Response to Submissions SSD-8586218

Lot 4 Skyline Crescent, Leppington
Bringelly Road Business Hub - Temperature
Controlled Warehouse Facility

14 October 2020 2200444

Drawing Name:
Landscape Cover Sheet

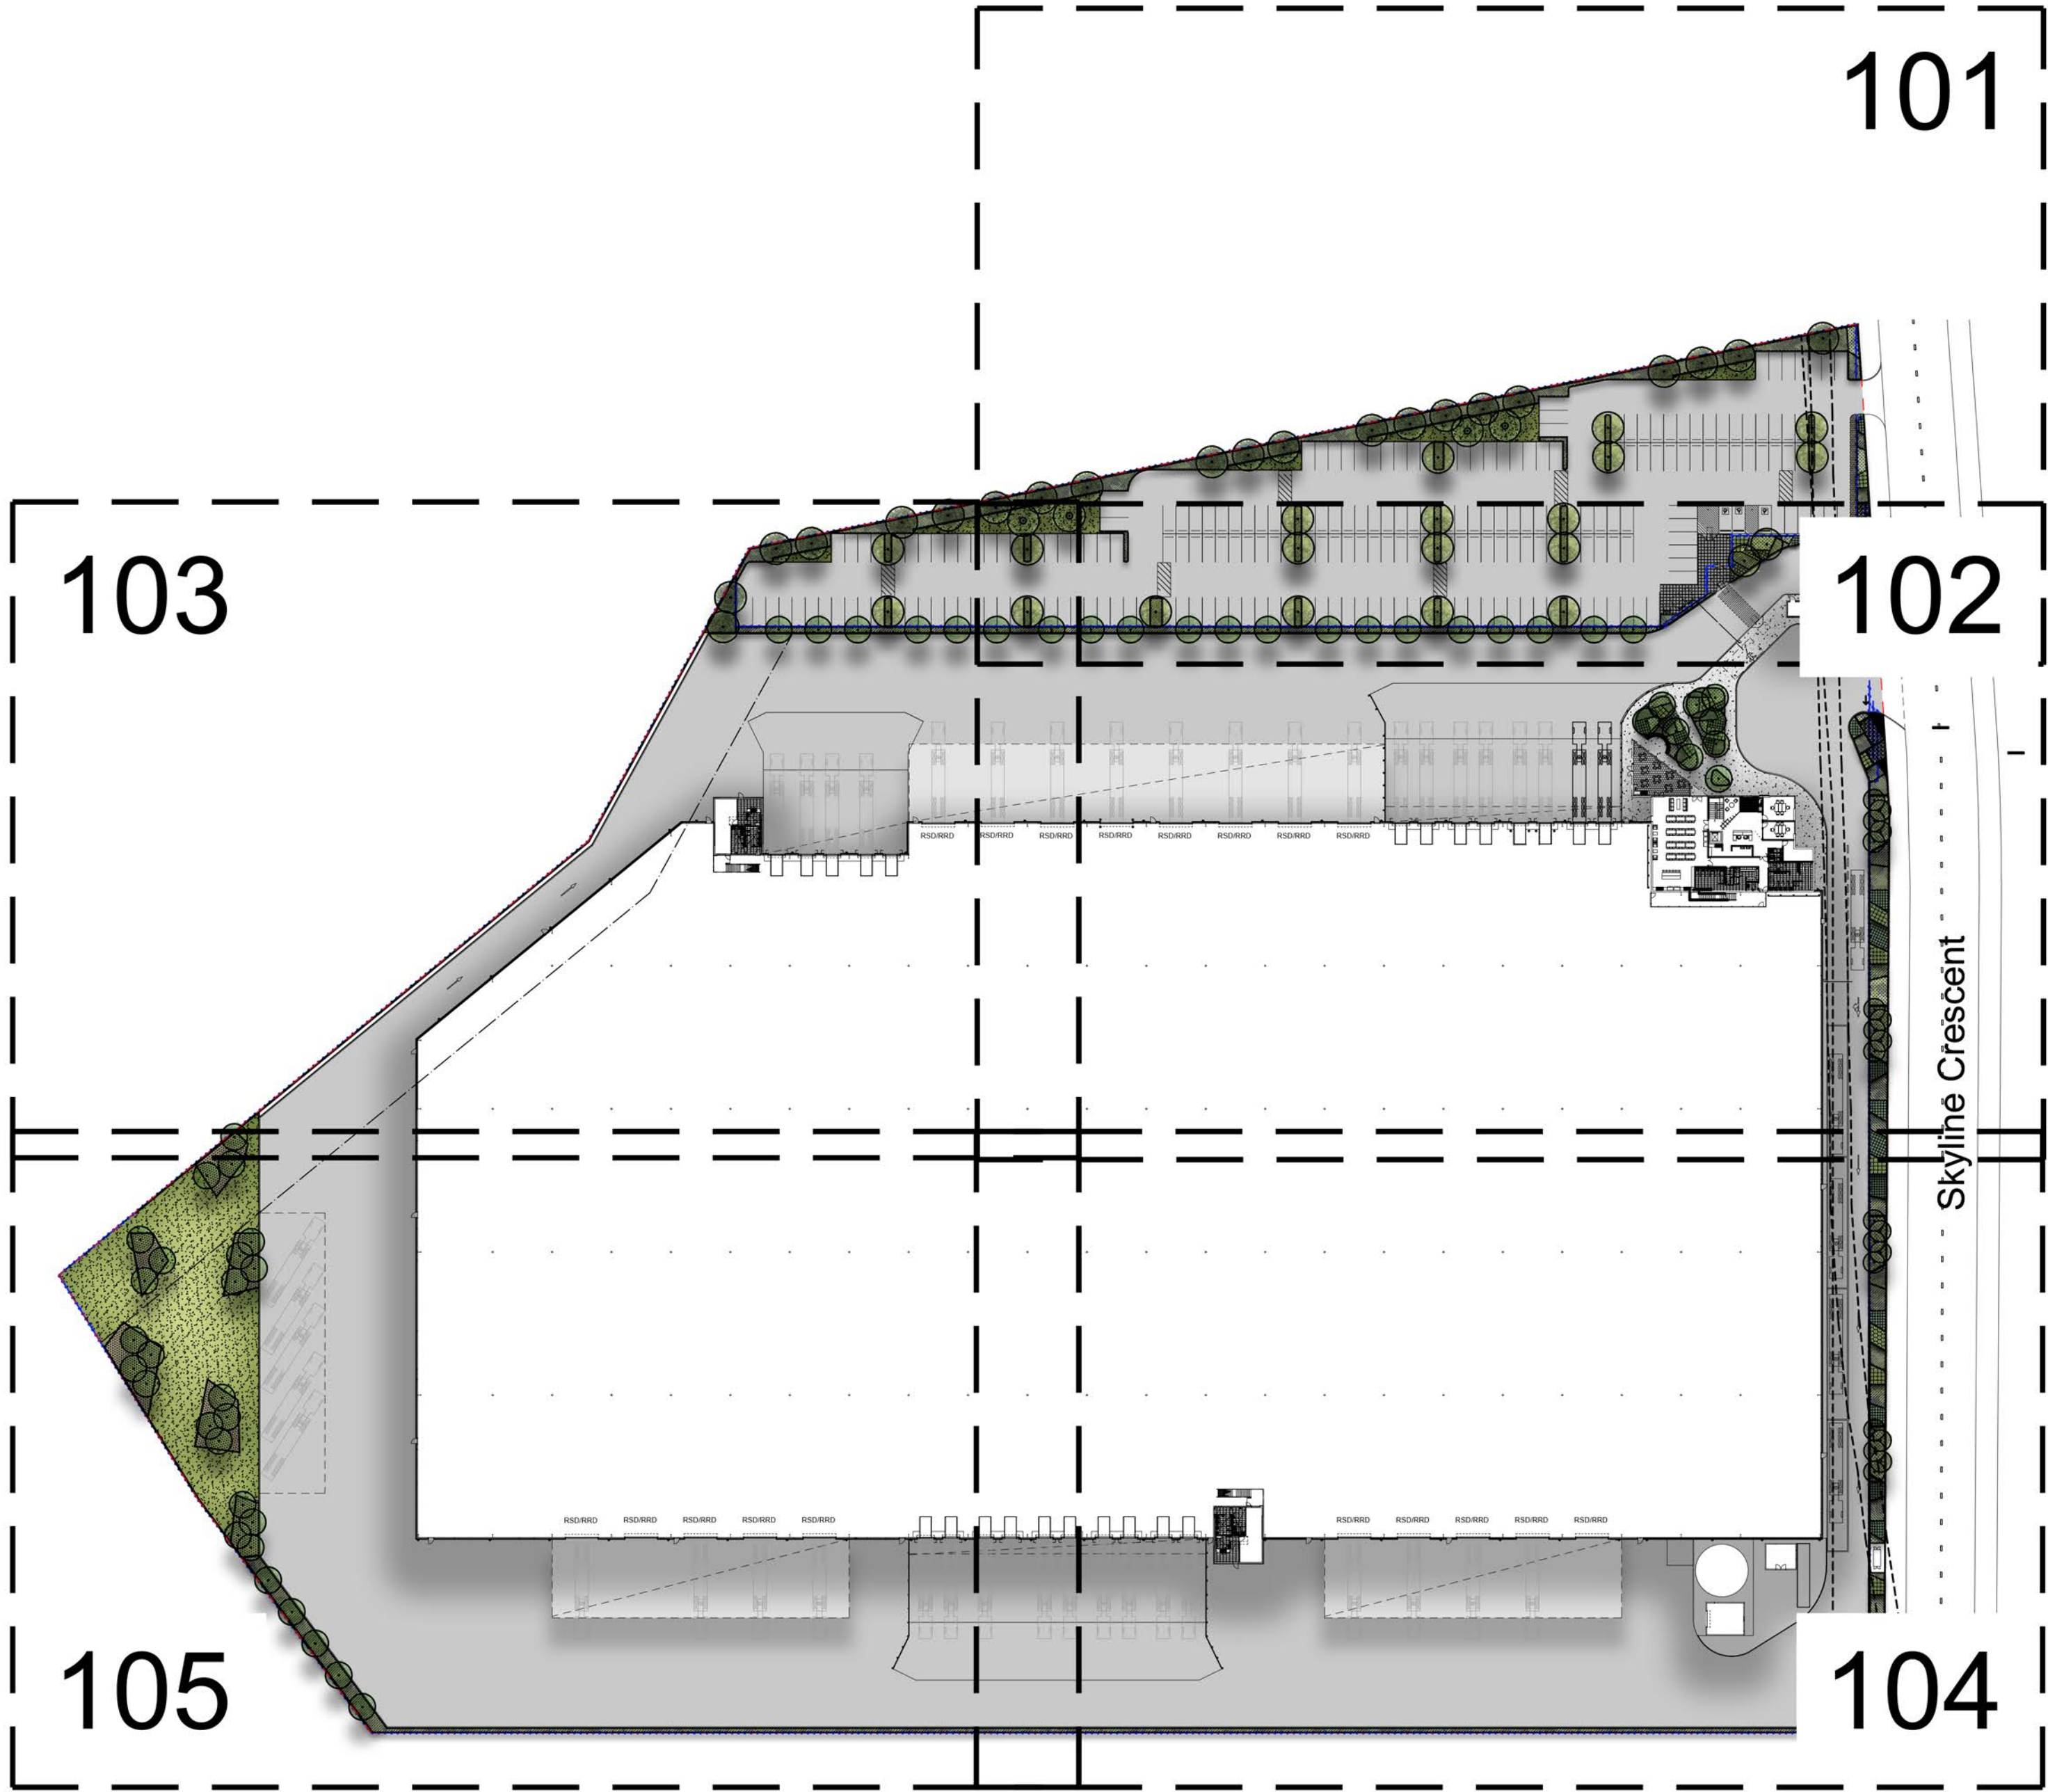
Comment	Response
<p>Built Form</p>	
<p>It is acknowledged the proposal meets the Site Design Guideline’s setback requirements in relation to the Stuart Road boundary, however, part 2.1(1)(b) requires a 5 metre (m) wide vegetation buffer to this boundary, the development proposes 3 m.</p> <p>In addition, 2.5(5) also requires a 15m setback from the boundary to the riparian zone, however, the development proposes approximately 8.4m.</p> <p>Appendix E “Compliance with Design Guidelines” does not address these inconsistencies. Please provide a full assessment of any inconsistencies between the proposal and the controls, and if required, make changes to any of the supporting documentation for the Development Application (architectural plans, landscape plans etc).</p> <p>It is noted the architectural drawings show roof plants with approximate heights only, resulting in a building height of 15.7m. Part 2.3(4) of Site Design Guidelines notes maximum height is 14m, with taller buildings permitted where it can be demonstrated certain criterion can be met. A review of the EIS does not appear to address the height inconsistency with the concept approval. As such, please provide clarification on the building height, a full assessment against the guidelines and if required, make changes to the architectural plans.</p>	<p>Consideration against Site Design Guidelines Part 2.1(1)(b) Section 2.1(1)(b) does not include a guideline that requires a minimum dimension. The Stuart Road building setback area is 1,670sqm. The landscaped portion of the Stuart Road setback area is 1,020sqm which equates to 61% and is generally compliant with the requirements of the guideline.</p> <p>Consideration against Site Design Guidelines Part 2.5(5) The guideline to setback 15m to the northern boundary where it adjoins the riparian corridor reflects the requirement for a 15m asset protection zone in this location. The proposal seeks to vary the guideline to facilitate the spatial and operational requirements of the temperature-controlled warehouse operator without creating any additional fire safety risks. The Bushfire Protection Assessment submitted as Appendix J with the EIS concludes that the proposal meets the objectives of ‘<i>Planning for Bush Fire Protection 2019</i>’. The proposal is also consistent with the setback objectives in the Site Design Guidelines as outlined below.</p> <ul style="list-style-type: none"> • <i>To encourage buildings that respond to the relative position of the site.</i> <p>The proposal complies with the setback guidelines for the public domain interfaces with Skyline Crescent and Stuart Road. As stated above, the 15m setback to the Bedwell Park riparian corridor is informed by the 15m APZ; as the guideline setback to the eastern boundary with the neighbouring private property is 5m. The Bushfire Protection Assessment confirms that the proposed setback will not create any additional fire safety risk. Condition B4(b) on the development consent for SSD 6324 Concept Plan requires</p> <p><i>“landscape buffer planting within the Bedwell Park riparian corridor immediately adjacent to the northern/north-eastern boundaries of lots 4, 6 and 8, comprising a mixture of native groundcovers, grasses, shrubs and trees that would complement the existing vegetation within the riparian corridor.”</i></p> <p>The landscape buffer planting will provide an additional visual buffer between the proposal and Bedwell Park.</p> <p>For these reasons, the proposed building provides an appropriate response to its relative position on the site.</p> <ul style="list-style-type: none"> • <i>To provide an open streetscape with substantial areas for landscaping.</i>

<p>Council commends the incorporation of landscaping at the site. Notwithstanding this, it is important to maximise the amount of landscaping to ensure an optimal sustainability outcome. Having regard to the submitted traffic report, it is noted that there are hardstand areas adjacent to the perimeter planting that do not appear to be required for vehicle manoeuvring and/or parking. In this case, there appears to be scope for an increase in landscaped areas around the perimeter of the site.</p>	<p>The proposal complies with the relevant Site Design Guidelines for on-site landscaping. The proposed hardstand is appropriate for the size and operations of the warehouse facility.</p>
<p>Council has reviewed the submitted landscape plan prepared by Habit8. It is noted that this plan indicates planting on the site yet does not denote the plant species. Furthermore, it is noted that the plant schedule does not provide details of the height and the canopy spread of each plant species. The landscape plan should be amended to rectify these matters.</p> <p>Notwithstanding this, having regard to the submitted visual assessment, it is noted that the trees used on the site, especially those in the car park area and along the Stuart Street frontage do not appear to provide large canopy cover. It is recommended that the applicant provide for species with a larger canopy to provide more shaded areas and adequate screening.</p>	<p>An updated landscape plan has been provided under separate cover. The plan provides species details. The level of detail is consistent with the level detail provided for SSD-8900 Steelforce Facility and SSD-9511 CFC Warehouse/Retail Facility.</p>

Comment	Response
	<p>The proposal contributes to the provision of an open streetscape along Skyline Crescent and Stuart Road. The building is setback in accordance with the guidelines and includes suitable and compliant landscaping areas that will soften the appearance as well as allow visual connectivity between the public domain and the warehouse.</p> <ul style="list-style-type: none"> <i>To ensure the provision of appropriate buffers to Bringelly Road, Stuart Road and internal roads that softens the visual impact of the development whilst allowing visibility to appropriate development.</i> <p>As above, the building is setback in accordance with the guidelines and includes suitable and compliant landscaping areas that will soften the appearance as well as allow visual connectivity between the public domain and the warehouse.</p> <p>Consideration against Site Design Guidelines Part 2.5(5)</p> <p>The Concept Plan approval does not place any limits on the building height. The proposed roof ridge height is 13.7m which is below the guideline height limit. It is proposed that 14 x plant units will have a maximum height of 15.8m. In accordance with part 2.3(4) of the Site Design Guidelines, the proposed height is appropriate in the circumstances for the following reasons:</p> <ul style="list-style-type: none"> <i>the proposed height is in keeping with the character of the locality;</i> <p>The predominant building height is 13.7m which is below the guideline height limit of 14m. The site is located with a business park hub which is undergoing rapid development to facilitate employment generating land uses in accordance with the Concept Approval. The proposal is immediately west of 2 x large industrial warehouse buildings that have an approved height of 13.7m. The predominant height is consistent with the height of the adjacent buildings and in keeping with the character of the estate. The taller roof plant units will not alter the proposal's consistency with the character of the locality.</p> <ul style="list-style-type: none"> <i>the building, or any part thereof, is not visually obtrusive</i> <p>A Visual Impact Assessment was submitted as Appendix O with the EIS. The VIA concluded that only one viewpoint will see any significant change in the landscape context and that:</p> <p><i>“the view impact is considered low due to the surrounding industrial site context with existing warehouses on both sides”</i></p> <p>The building will not be visually obtrusive.</p> <ul style="list-style-type: none"> <i>the overall design of the development, including landscaping and building materials, reduces the impact of height and bulk of the building.</i> <p>As outlined above the predominant height of the building is below the guideline limit of 14m. The taller elements are limited to roof plant units. The building is extremely large and has been designed using materials typical to a contemporary warehouse development. The length and scale of the building elevations will reduce any visual impact of the taller plant units.</p>

Comment	Response
	<p>In addition, landscaping is proposed along the Stuart Road and Skyline Crescent frontages which will further reduce any visual impact. The VIA submitted with the EIS concluded that:</p> <p><i>“the development will be heavily landscaped in setbacks surrounding the site helping to soften and screen views for these users. It should also be noted that these users living along and/or traveling in an east-west direction along Bringelly road are currently experience views which include the current warehouse facilities of the same scale as the one on which this report is based.</i></p> <p><i>Wider reaching views to the site from residential areas located in the greater landscape have also been considered, however the site is buffered heavily from the north east through a vacant vegetation corridor making views to the site negligible.”</i></p> <p>For these reasons the overall design will reduce the impact of the taller roof plant units.</p>
